From: [REDACTED]
Sent: 30 May 2025 16:29
To: Planning
Subject: Objection to Planning Application No: 3/2025/0083 - Proposed New Dwelling adjacent to The Old Vicarage, Gisburn

Objection to Planning Application No: 3/2025/0083 - Proposed New Dwelling adjacent to The Old Vicarage, Gisburn

Existing and proposed site sections

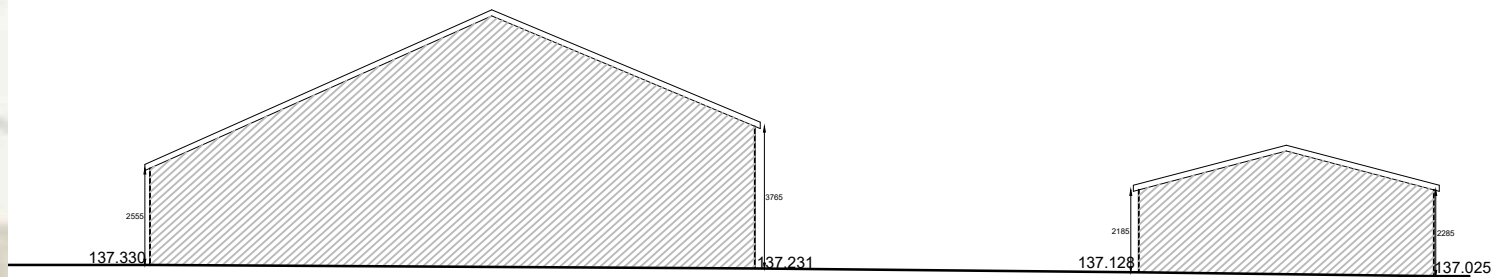
The proposed living building is [REDACTED]. The increase in height from the original 6.58 metres a distance away [REDACTED] exacerbates the issue, resulting in an overbearing [REDACTED], particularly during late afternoons and evenings. The effect on natural light [REDACTED]. This visual dominance is not in keeping with the scale and spacing typical of the area.

**Title:** Proposed Plans and Elevations  
-New Build

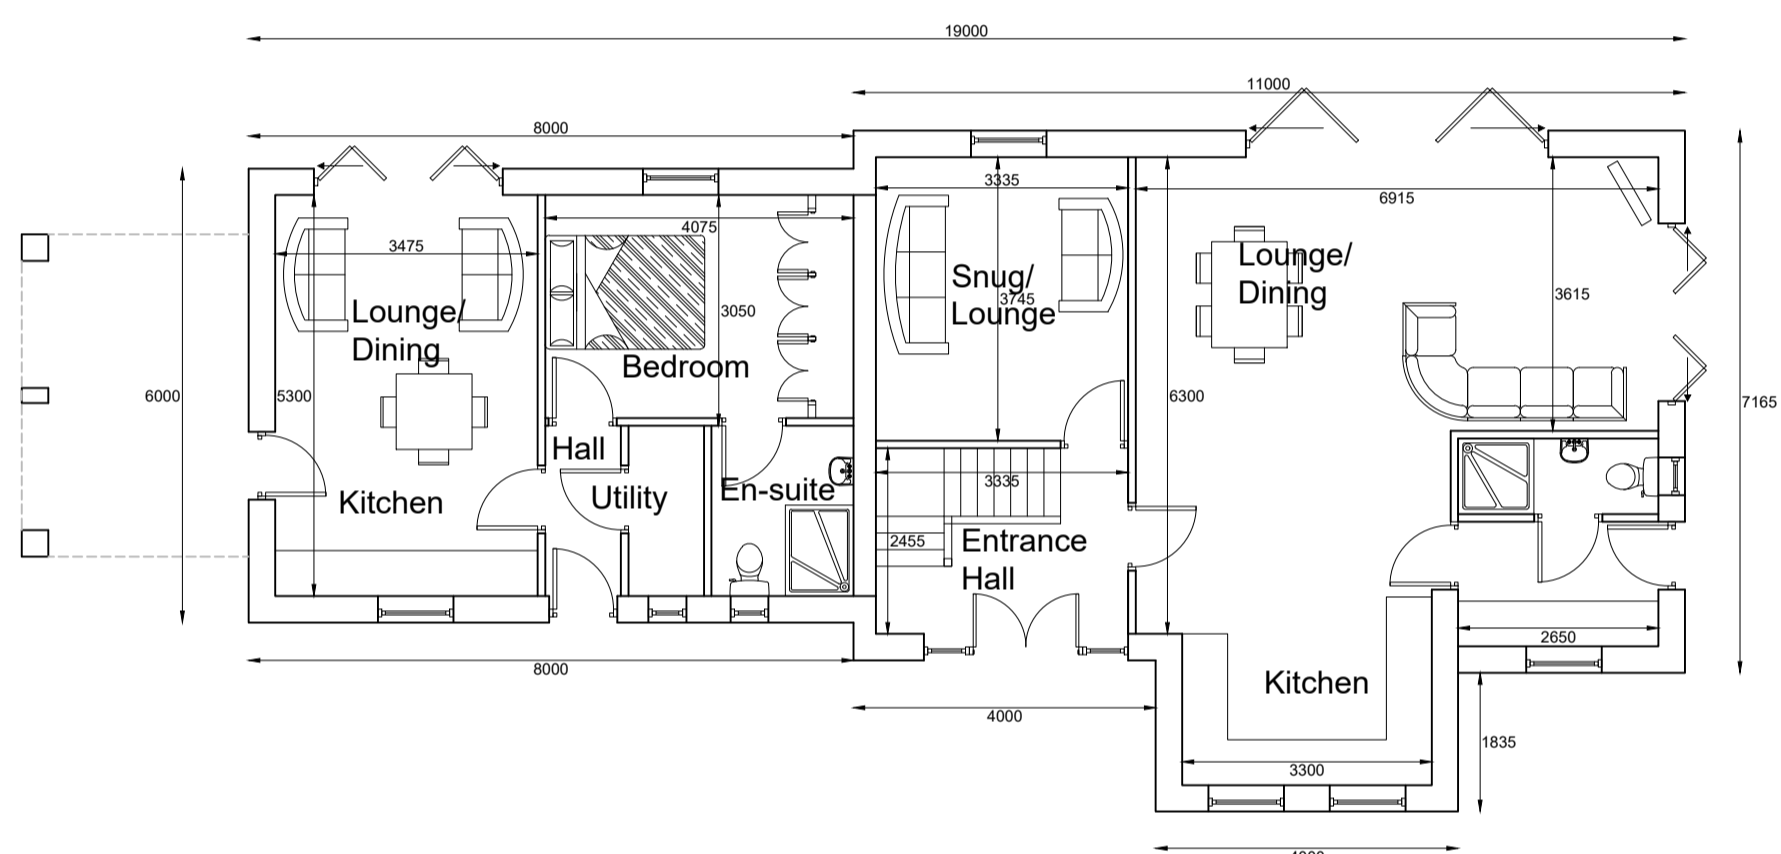
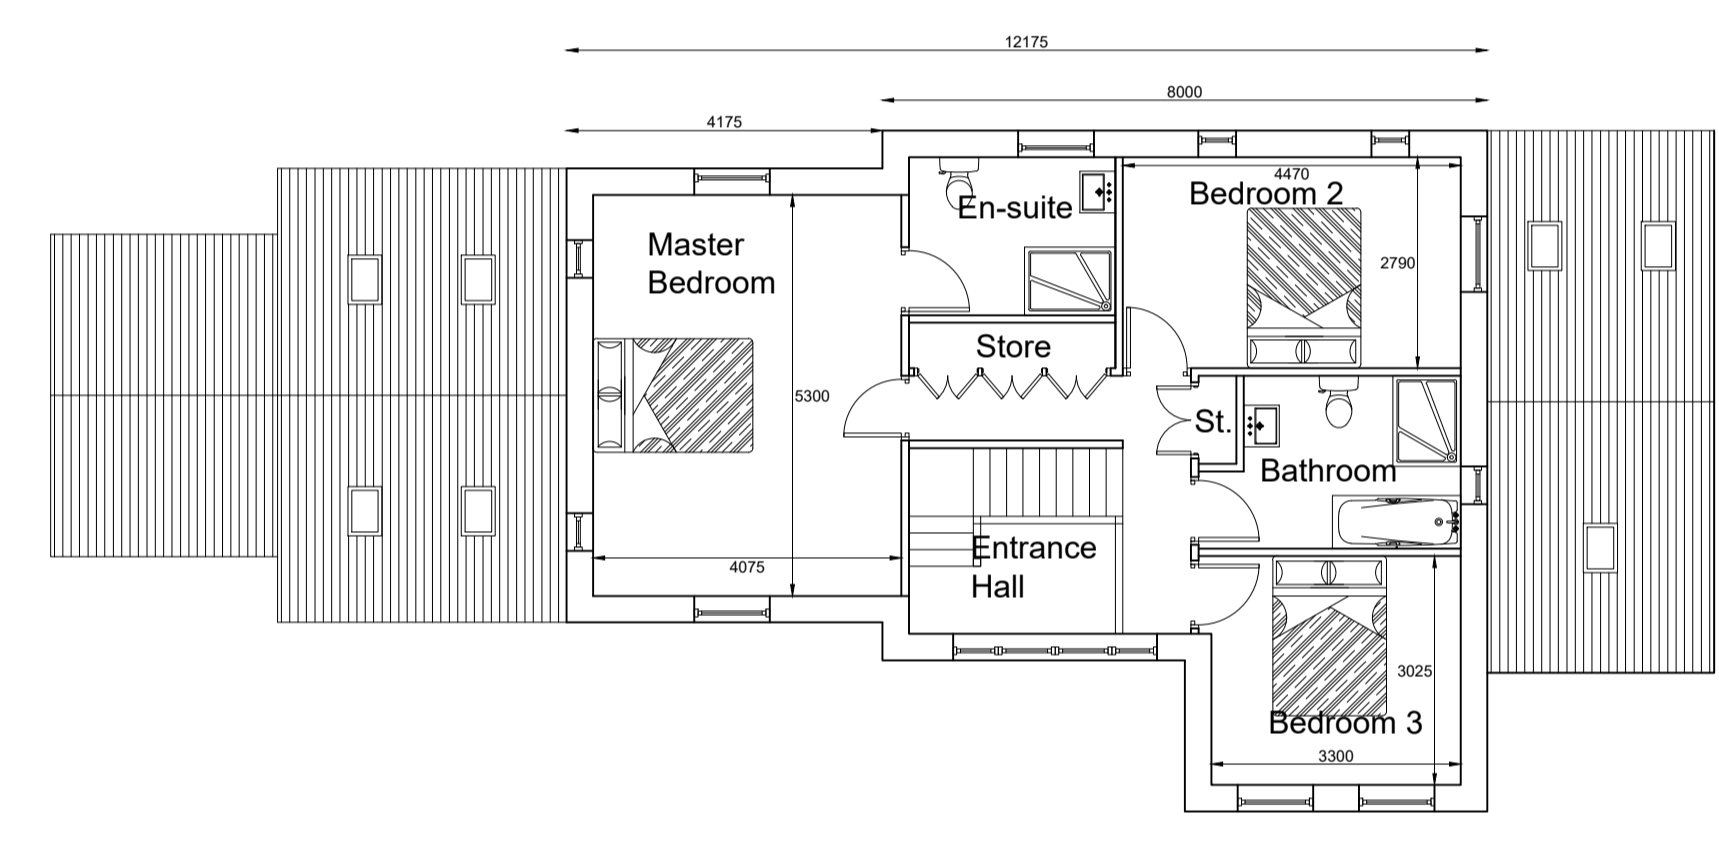
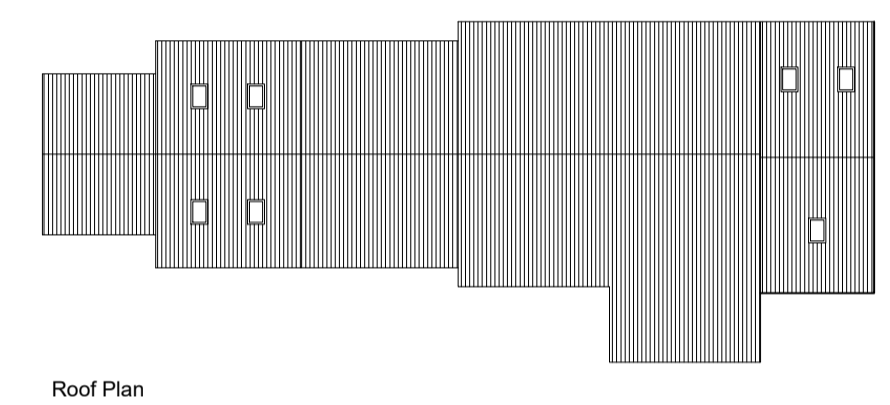
The proposed new detached house includes upstairs windows, one bedroom and one bathroom, that [REDACTED]. This represents a significant intrusion on our residential privacy and will fundamentally change the enjoyment of our home, [REDACTED] benefit from

a [REDACTED]. As the new house will be built within [REDACTED] this would result in an unacceptable [REDACTED] contrary to the principles of good design outlined in the National Planning Policy Framework (NPPF) and Ribble Valley's own planning policies.

Should the Council be minded to approve any development on the site, I urge that conditions be imposed to protect privacy e.g. repositioning of windows and to ensure the design remains sympathetic to the surrounding historic environment. As the proposal is for a self-build property, we are also concerned about prolonged disruption and construction noise. We request the council to ensure, that strict controls are applied to building hours eg. restricting early mornings, evenings and weekends and that a clearly defined, reasonable build timescale is enforced to minimise long-term disruption to neighbouring residents and businesses.

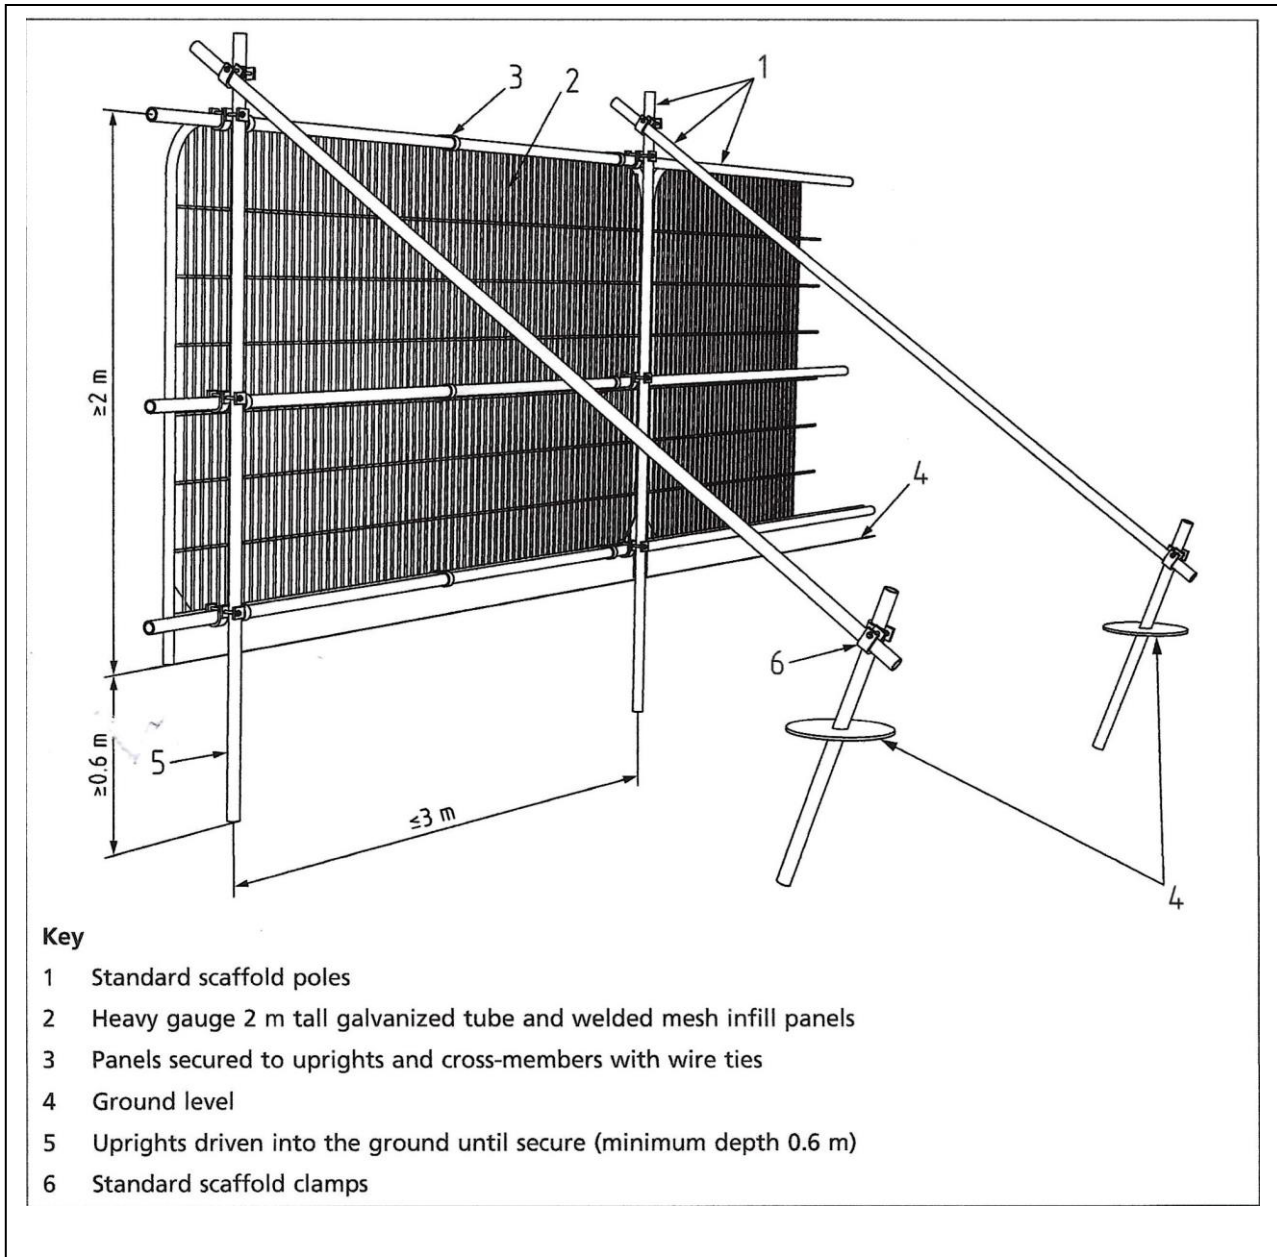
The application involves the removal of a mature, visually prominent 13-metre beech tree (T6), which as per the Tree Appraisal Nov 24 Report is in good, mature condition and of 'good structural form for the species'. This tree makes a significant contribution to the local landscape and conservation area character. Its removal for

development purposes is unjustified and contrary to local environmental and conservation policies.
